RE: Miller Short Plat, SP-26-00003 – Transmittal of Comments

Below are our responses to the comments that were attached to your letter dated May 18, 2026.

Table with 3 columns: KITITAS COUNTY, DATE, JOB NO.
DWN BY G.W. DATE 04/2026 JOB NO. 230053
CHKD BY D.L.P. SCALE N/A SHEET 1 OF 3

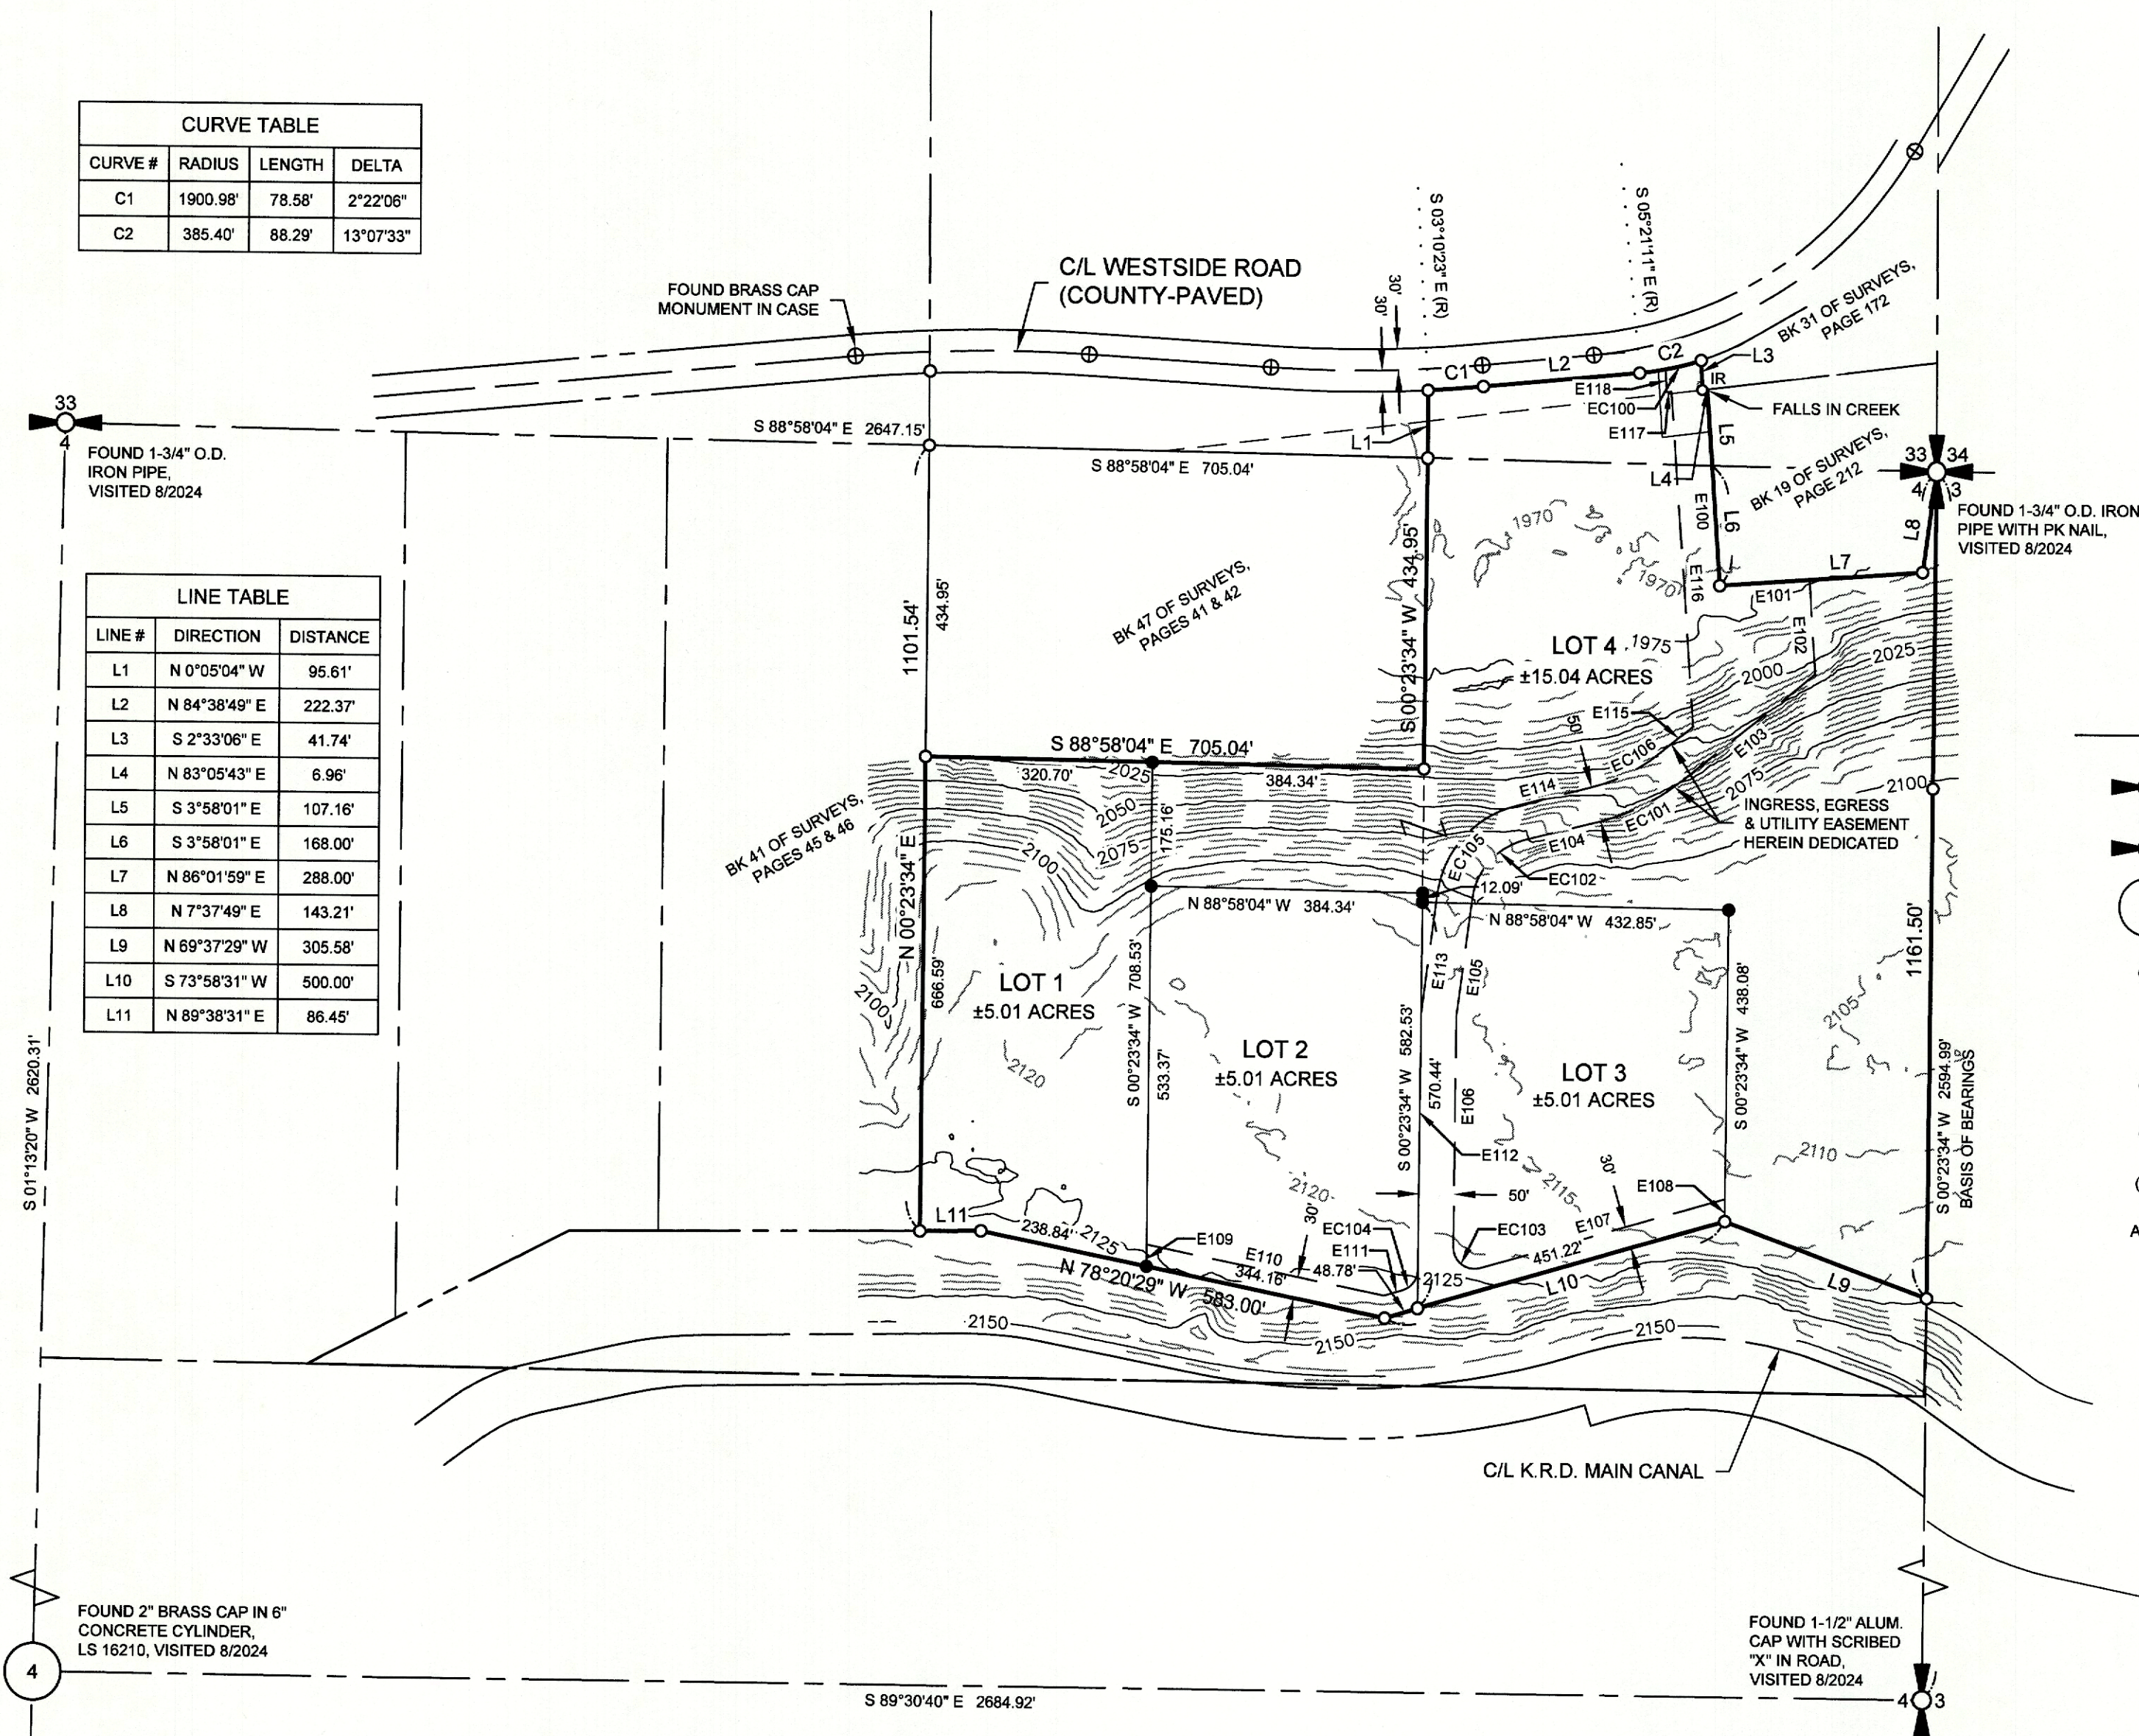
Plat Notes C-1 and C-2 have been placed on the short plat map.

RESPONSE: NOTES PLACED ON MAP

MILLER SHORT PLAT		
PREPARED FOR DON MILLER		
A PORTION OF SECTION 4 & SECTION 33, TWN. 19 N., RGE. 15 E. & TWN. 20 N., RGE 15 E., W.M.		
KITTITAS COUNTY WASHINGTON		
DWN BY <b>G.W.</b>	DATE <b>04/2026</b>	JOB NO. <b>230053</b>
CHKD BY <b>D.L.P.</b>	SCALE <b>1" = 200'</b>	SHEET <b>2 OF 3</b>

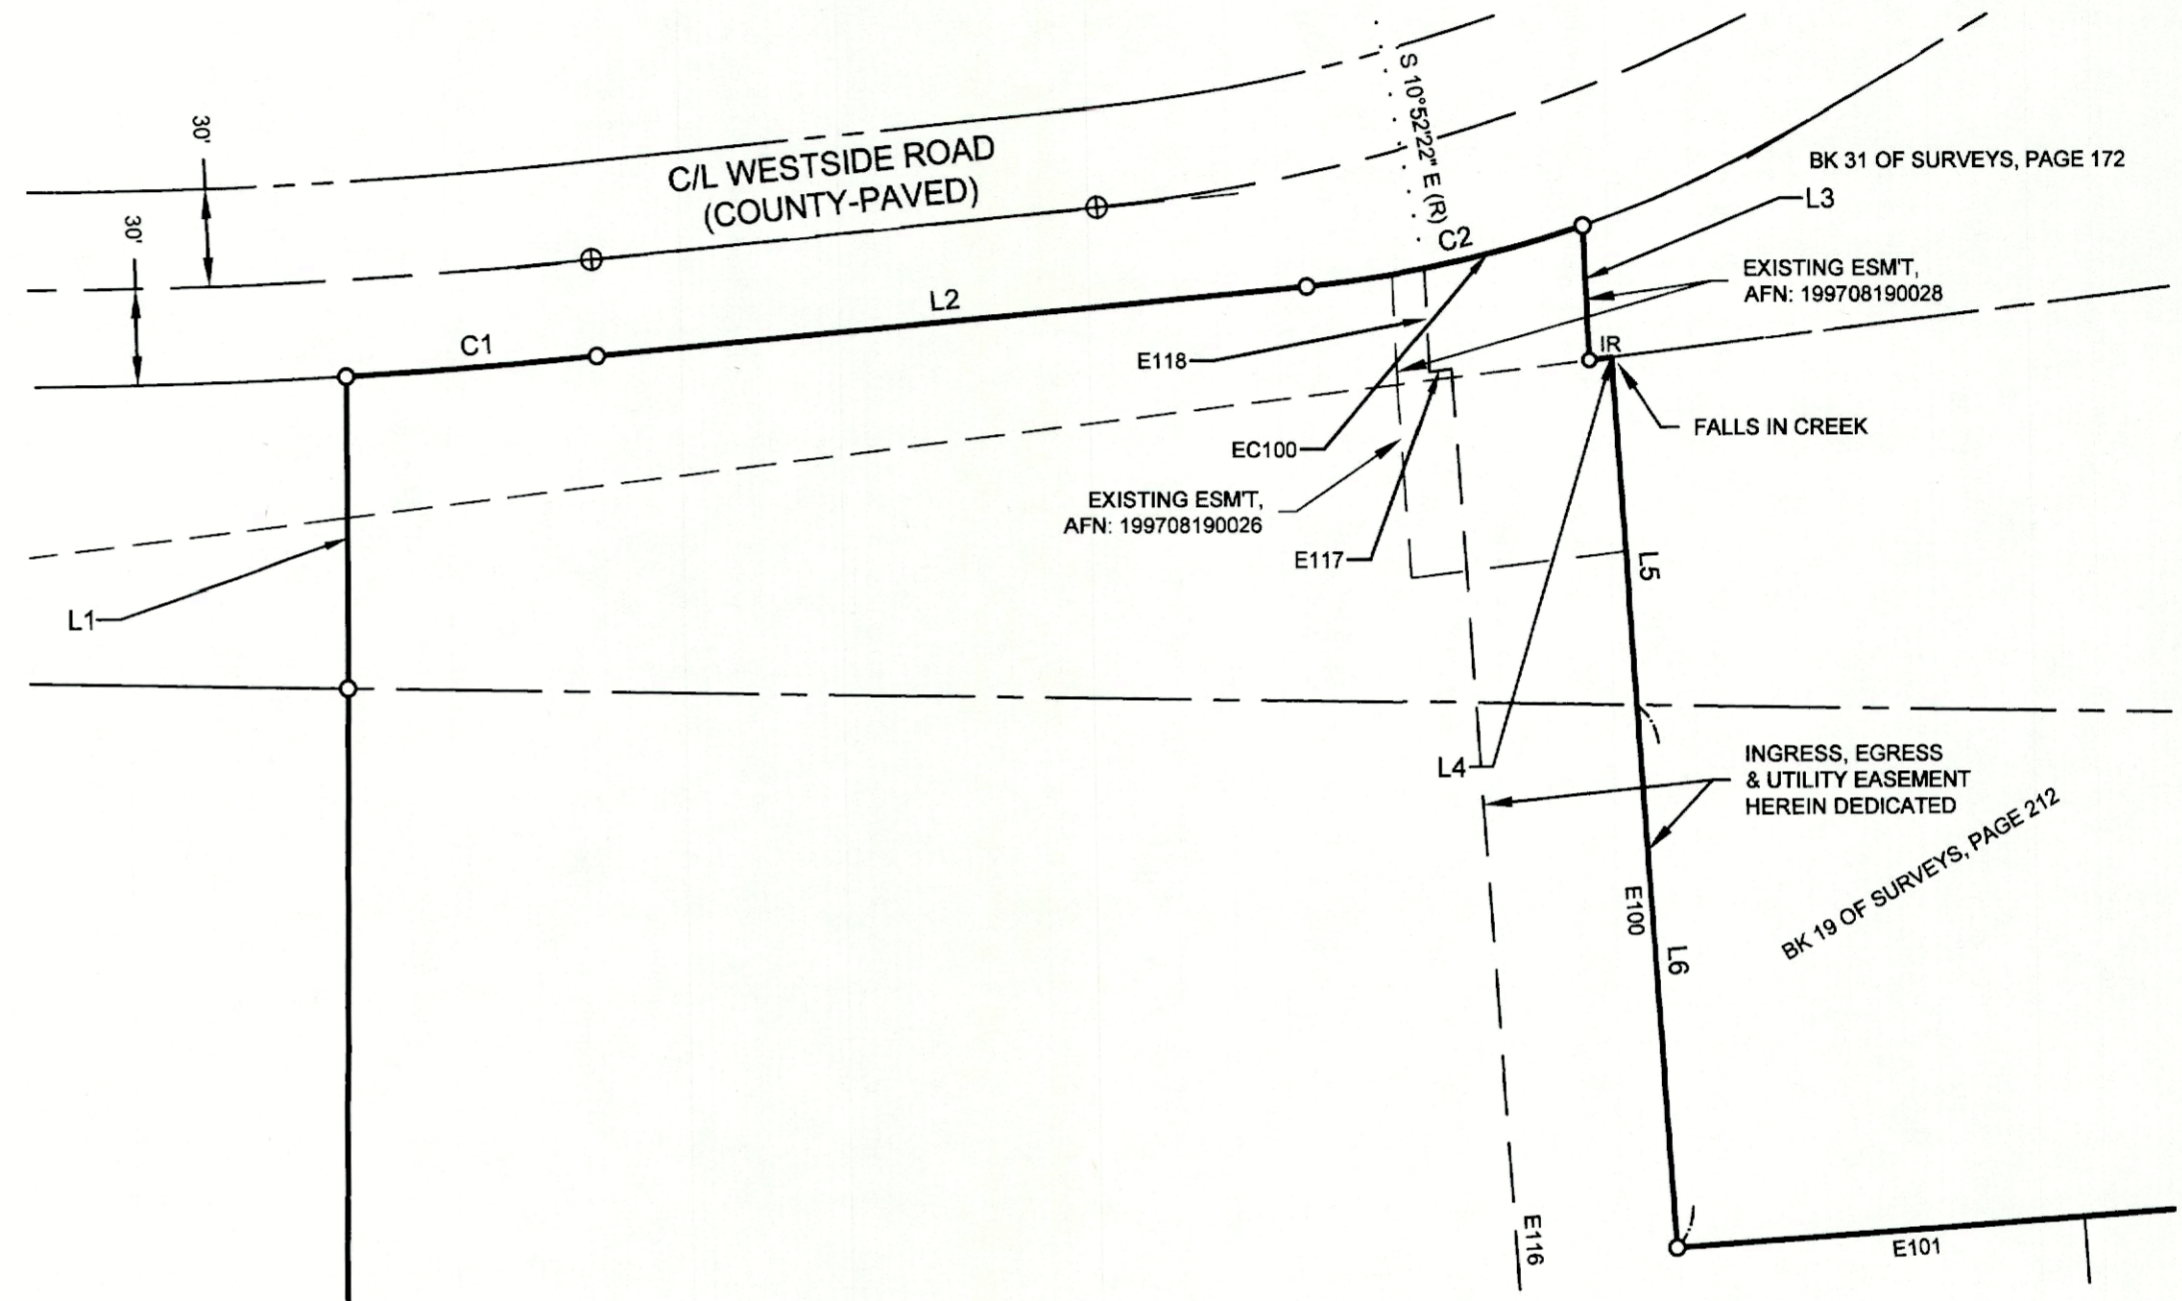
1. Application map does not meet requirements of WAC 332-130-145 Topo Standards.
2. If any road monuments or either of the 2 untied property corners were utilized for survey control, please include distance and bearing ties to these monuments.

OF NOTE (change not required for approval) 1. The area near the N'most corner of Lot 4 would benefit from a note "See Detail Next Sheet".

RESPONSE: NOTED. APPLICANT SHALL UPDATE THE MAP PRIOR TO FINAL PLAT.
